OUT18/11485

**North Byron Parklands Cultural Events Site (SSD 8169)  
Response to Submissions**

Alison Collaros  
A/Manager Assessment Advice  
**Lands and Water - Strategy and Policy**  
17 September 2018

01 SITE PLAN 01 (Rev05)  
NORTH BYRON PARKLANDS  
SCALE 1:500 @ A1

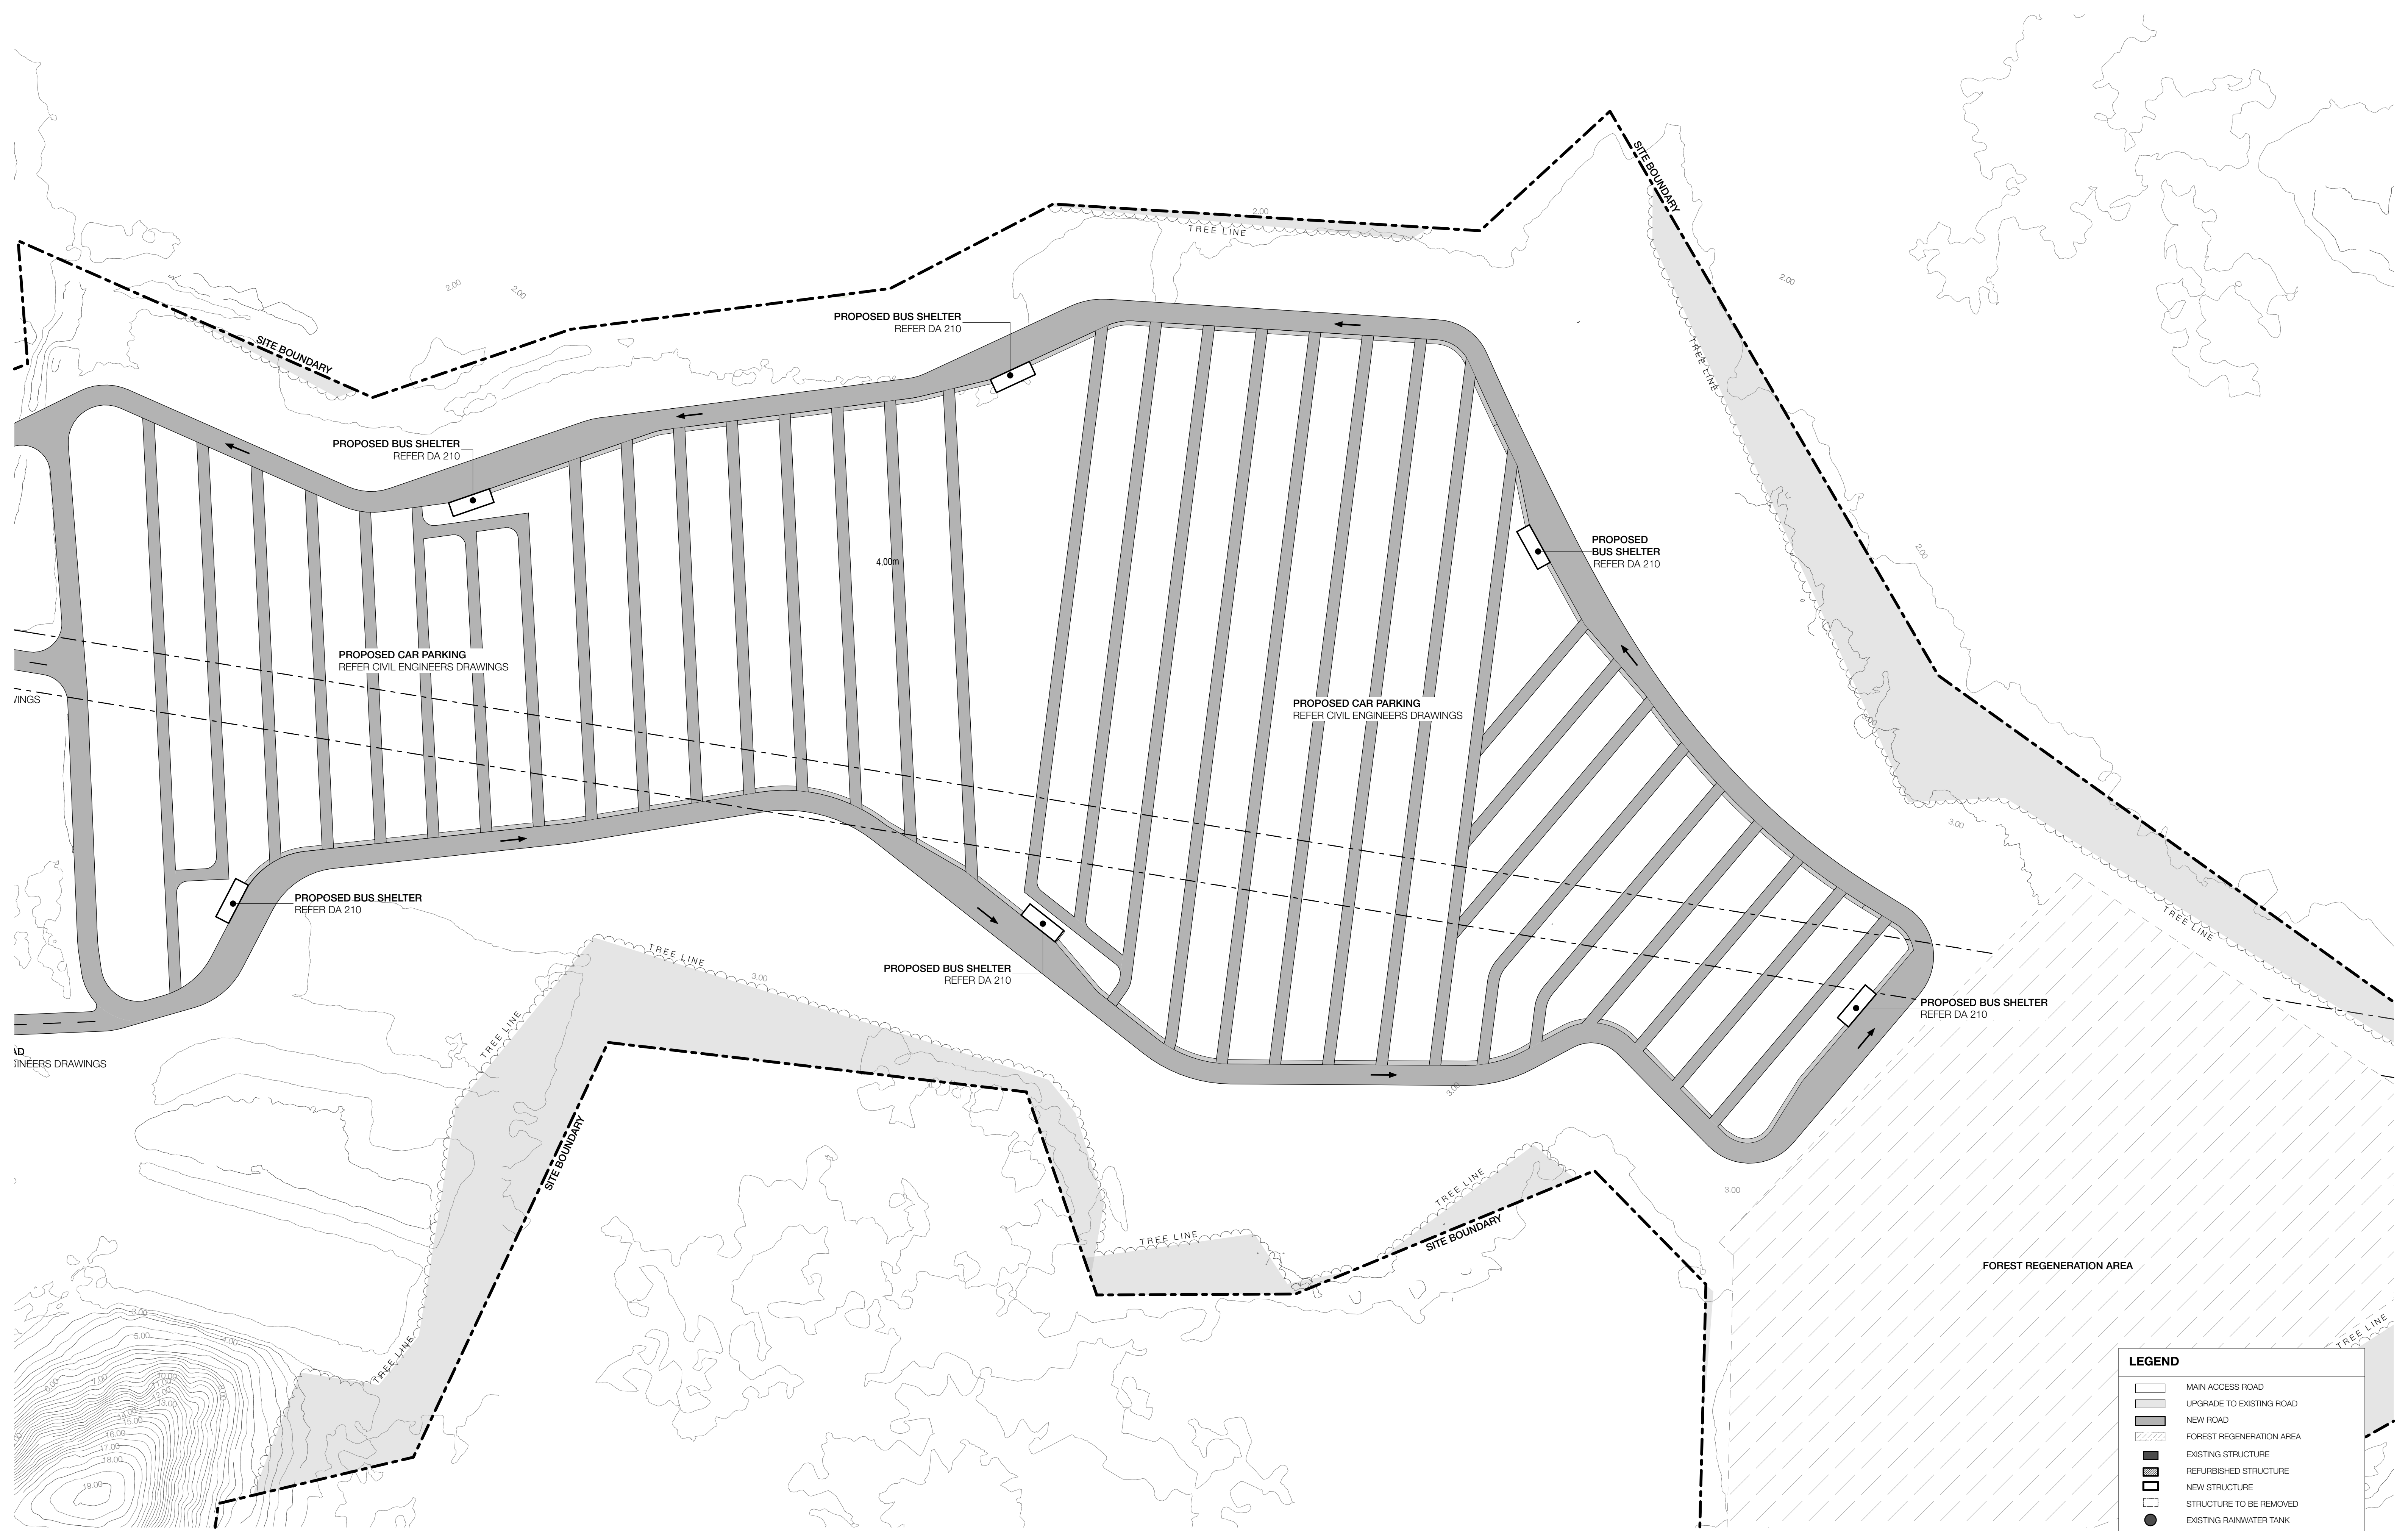
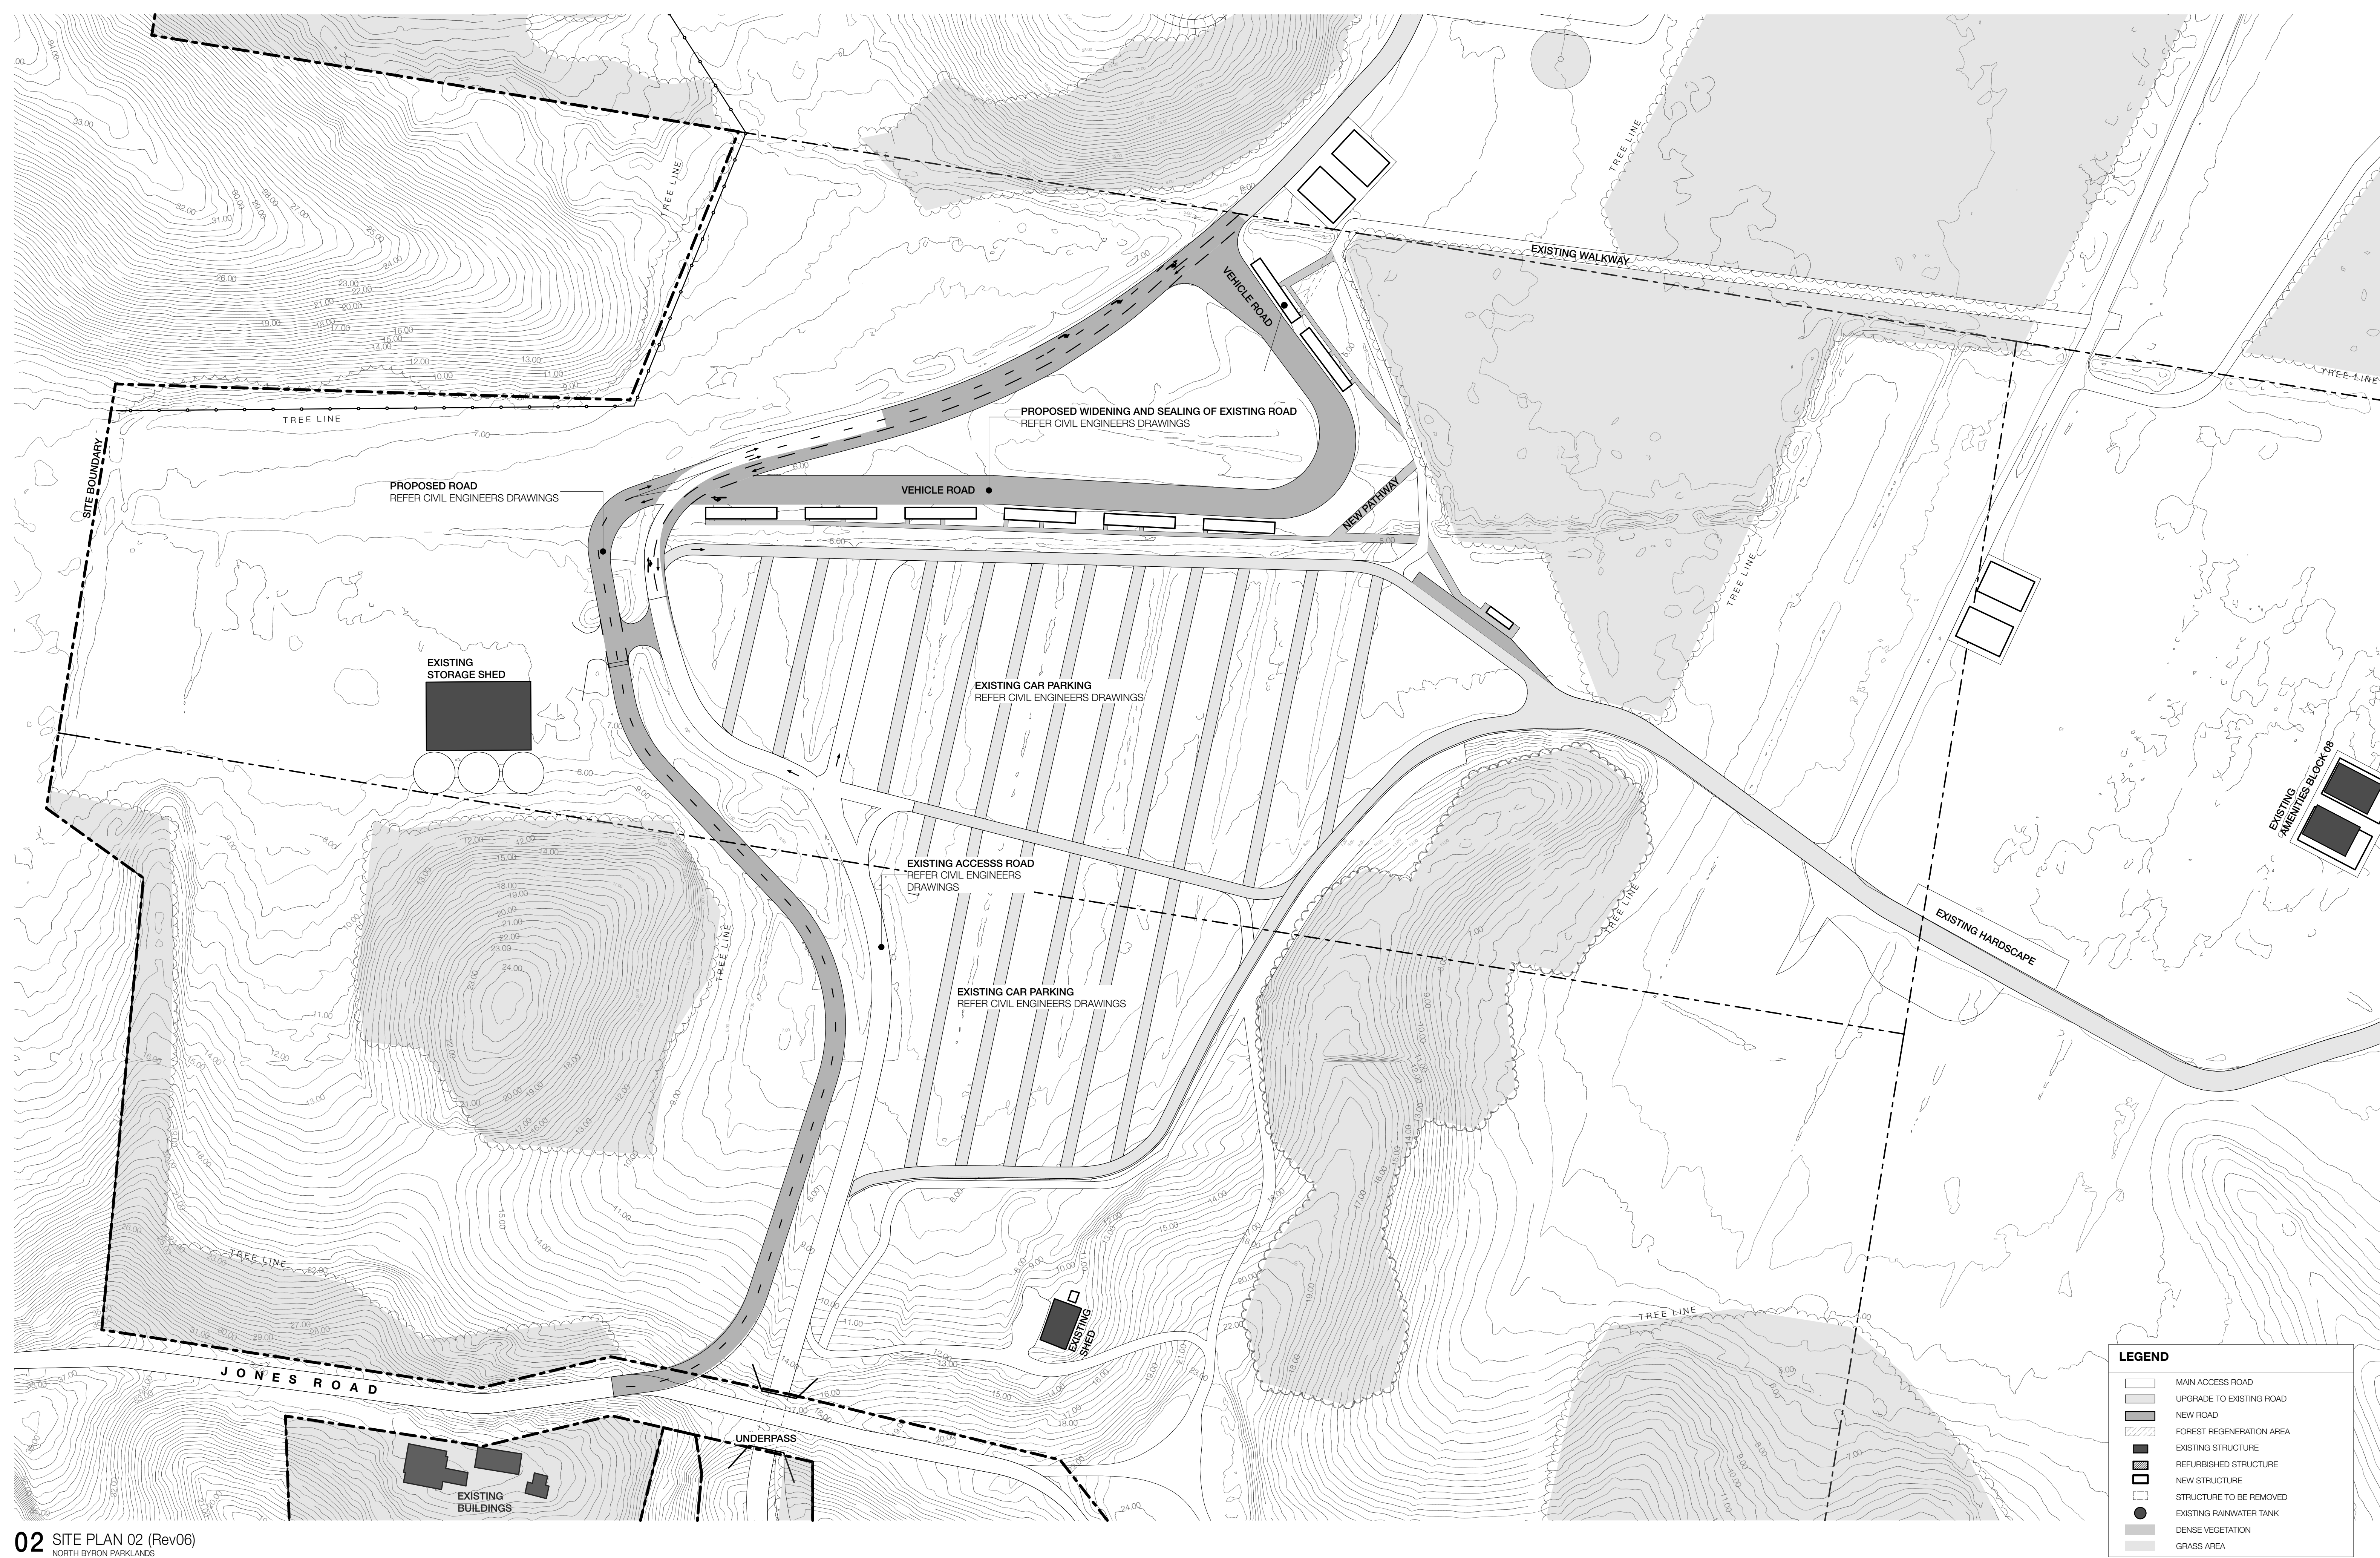
The RTS has not adequately demonstrated that it complies with the Guidelines for Controlled Activities on Waterfront Land (NRAR 2018). Specifically, the RTS has not incorporated vegetated buffer zones as requested in previous advice dated 16 February 2018. The proposal should include a:

- 20 metre vegetated buffer between Yelgun Creek (3rd order stream) and road near south west carpark, and
- 10 metre buffers between:
  - (i) proposed structures and the top water level of the existing dam near the conference centre,
  - (ii) conference centre car park and 2nd order stream, and
  - (iii) proposed amenities near existing bus stop (at western car park) and the top bank of the nearby watercourse.
